DECISION DELEGATED TO HEAD OF PLANNING

Application No: H14-0811-21 **Applicant:** Scottpark Developments Ltd.

Proposal: Residential Development - Erection of Dwelling

Location: Adj. 47 Milestone Lane Pinchbeck Spalding

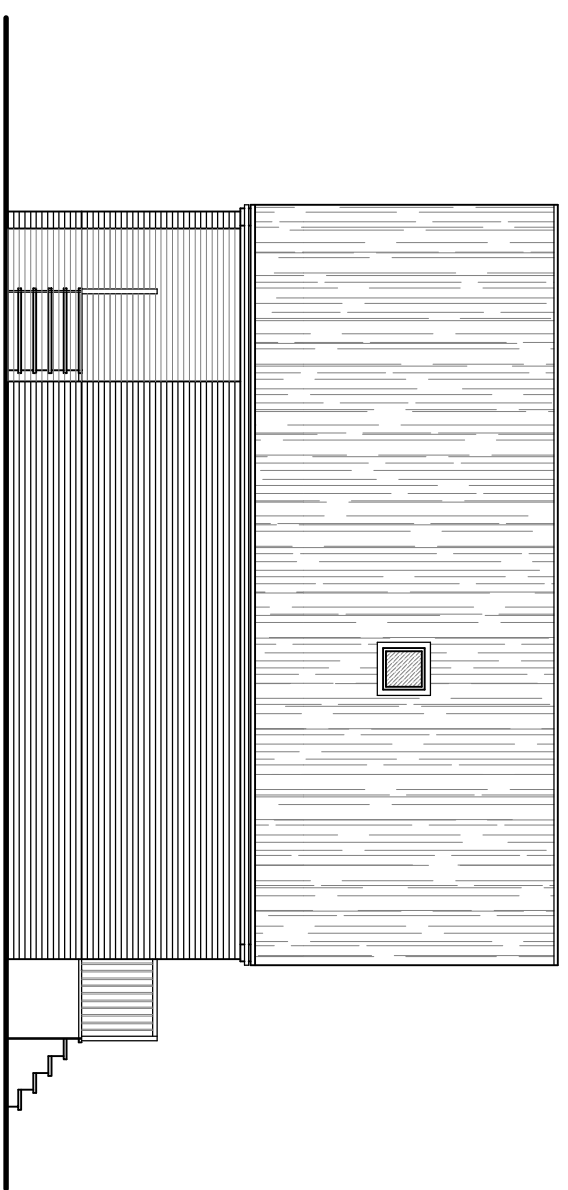
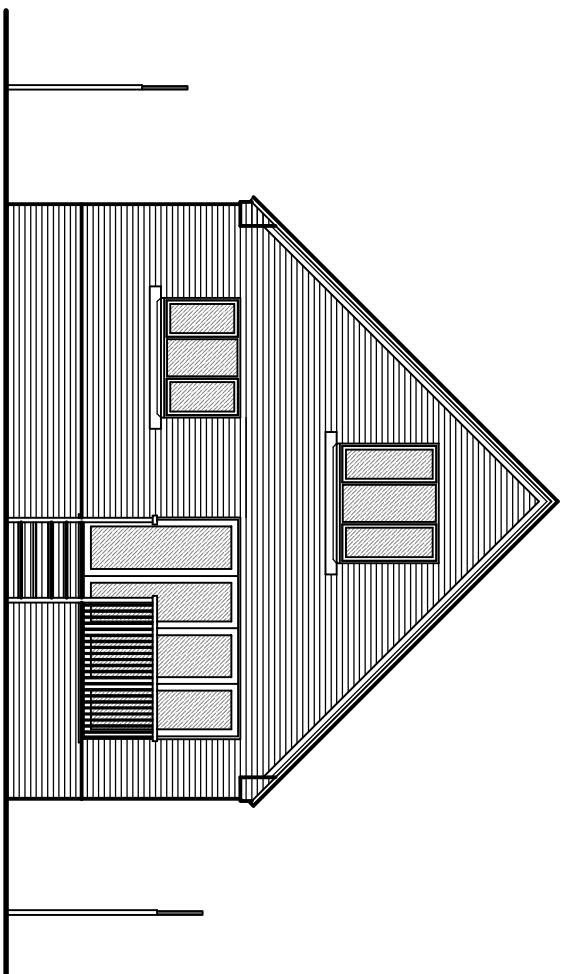
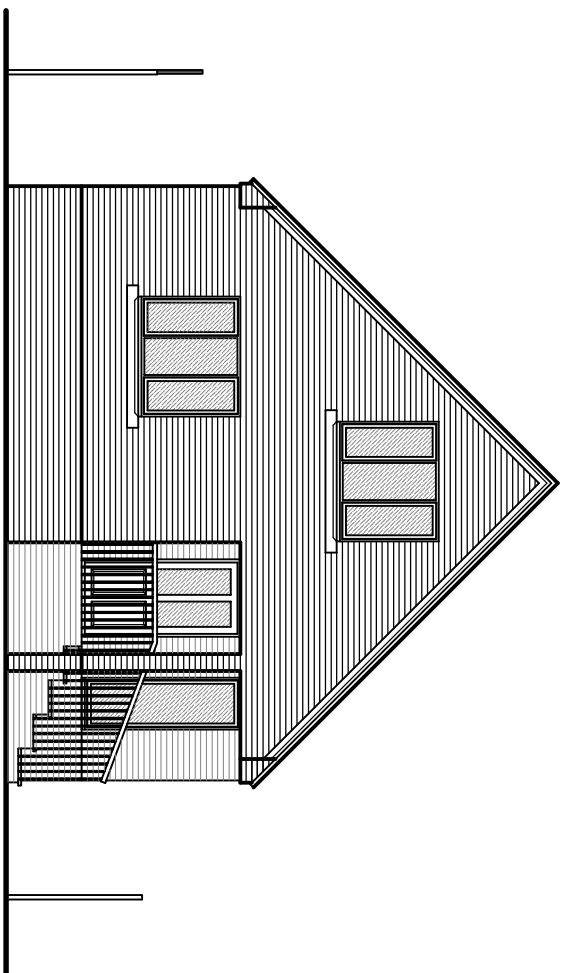
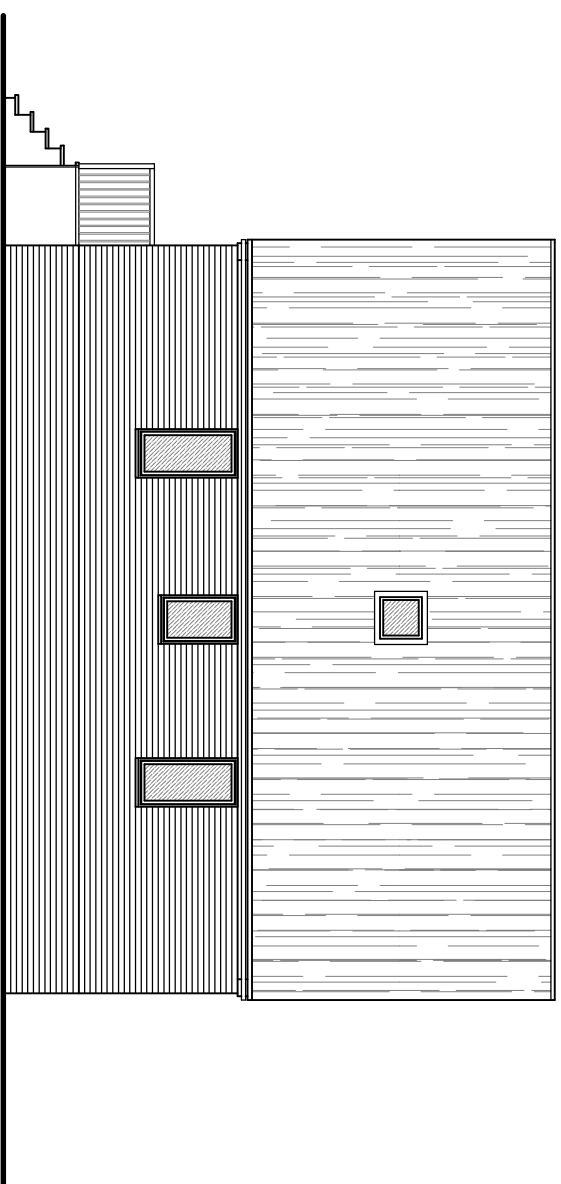
Existing houses on this part of Milestone Lane (as well as Bacons Lane) are typically situated on larger plots than the application site (the narrowest currently being approx. 10m in width). It is considered that the proposed dwelling would appear visually cramped within the plot and would be at odds with the character of existing development in the locality. In terms of the design of the proposed dwelling, due to the predicted flood depths, there is stepped access in order to enter the dwelling which is not in keeping with the design of other dwellings in the vicinity.

Objections have been received regarding the impacts of the proposal upon residential amenity of the surrounding neighbouring dwellings. A window to the north elevation at first floor faces towards the side elevation of no.5 Bacon's Lane. The rear elevation will be approx. 11.8m away from the obscure glazed window to the first floor of no.5 Bacons Lane. Although this separation distance is much less than the preferred 21m separation distance between facing windows, the existing window to no. 5 does not serve a room classed as habitable space in planning terms and is obscured glazed. Roof lights are proposed to the family bathroom and landing which are not considered to be a habitable rooms and would therefore not create a material overlooking impact.

The proposed boundary treatment to the sides and rear of the dwelling is 1.8m closeboard fencing with 300mm trellis above. Given the need to raise finished floor levels by 1m, this isn't sufficiently high enough to prevent overlooking from the side facing ground floor windows to the neighbouring garden. The bottom of these windows will sit at the top of the 1.8m fence and the top of the trellis will still be around 40cm below average eye height when measuring where the internal floor level would fall. There would therefore be a material overlooking impact from the side facing lounge and dining windows to the neighbouring garden (utility room classed as a non-habitable space)

SITE PLAN.
1/250.

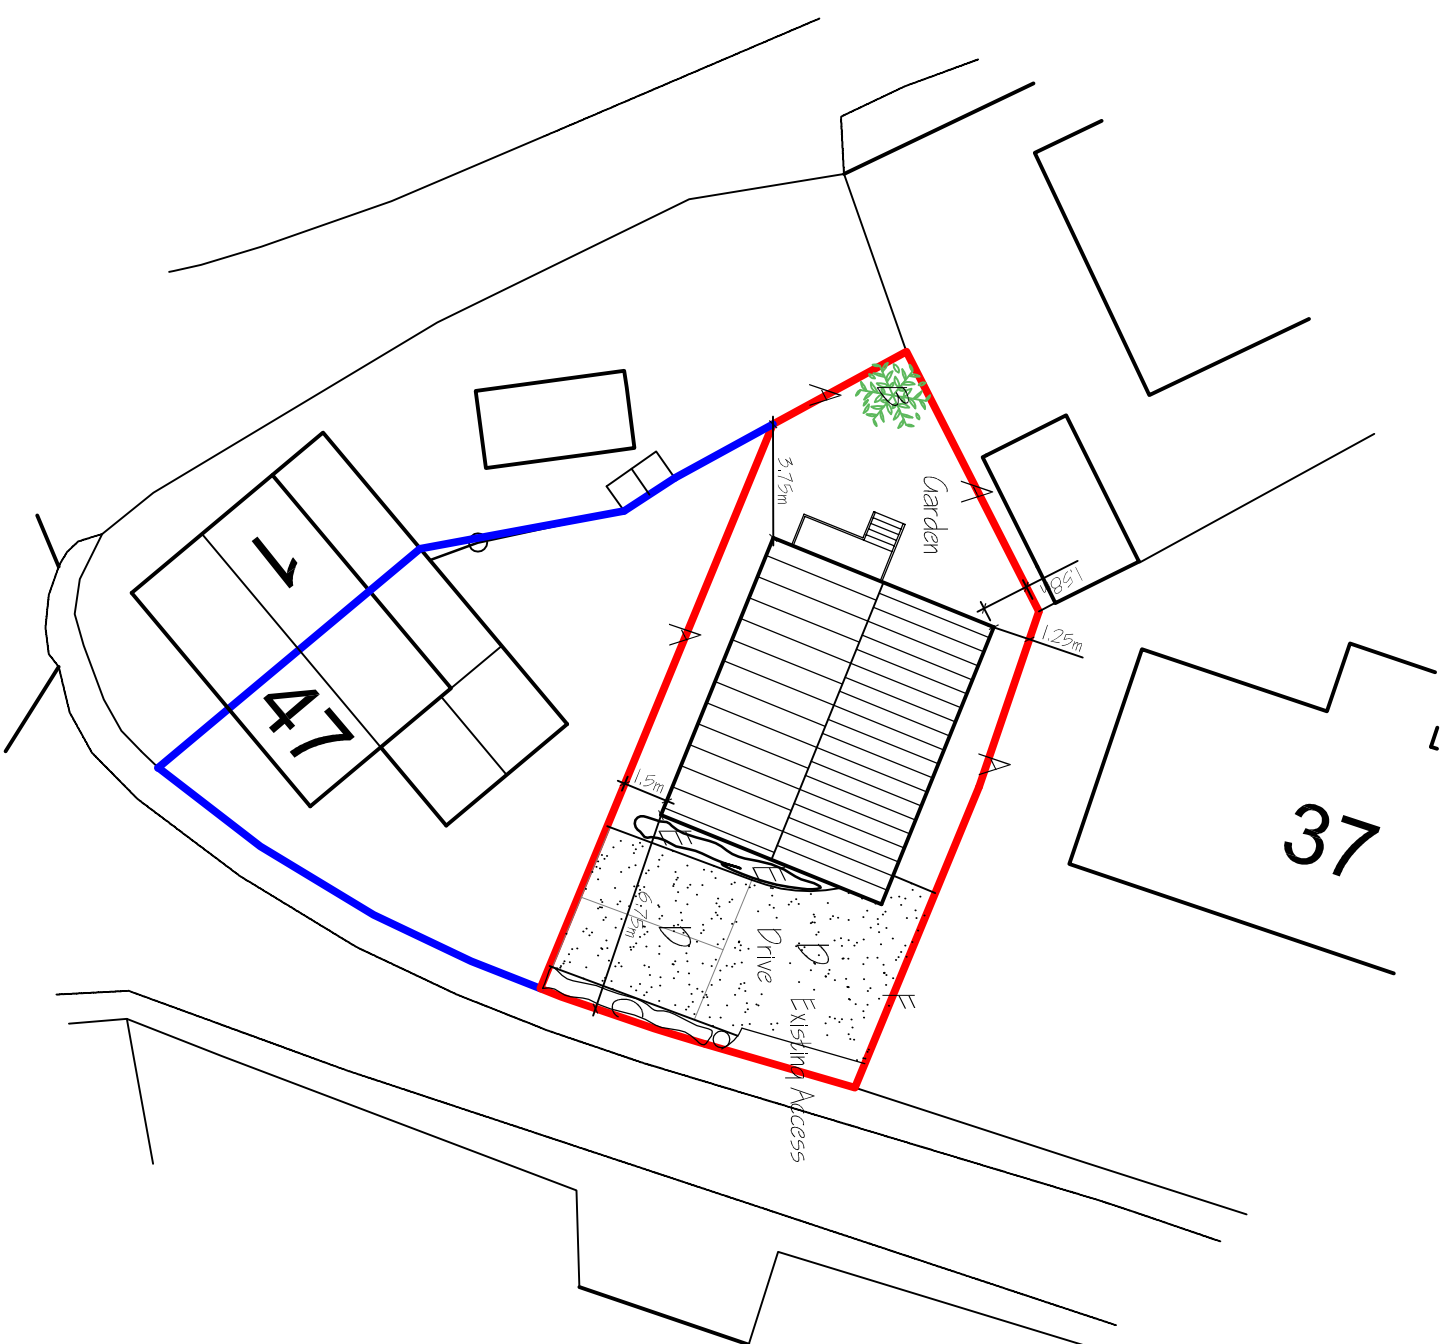
The proposed dwelling will measure approx. 9.8m in depth by approx. 7.7m in width. The overall depth of the site measures a maximum of 23.4m in depth and a overall width of approx. 10.8m. The northern side elevation of the proposed dwelling is approx. 5m away from the side elevation of the property at no.37 and approx. 4.1m to the side elevation to the property to the south.

Local Highways request to show where residents of host dwelling would park their vehicles, once the garage is removed. See H14-0730-21 for the proposed car spaces for the host dwelling.
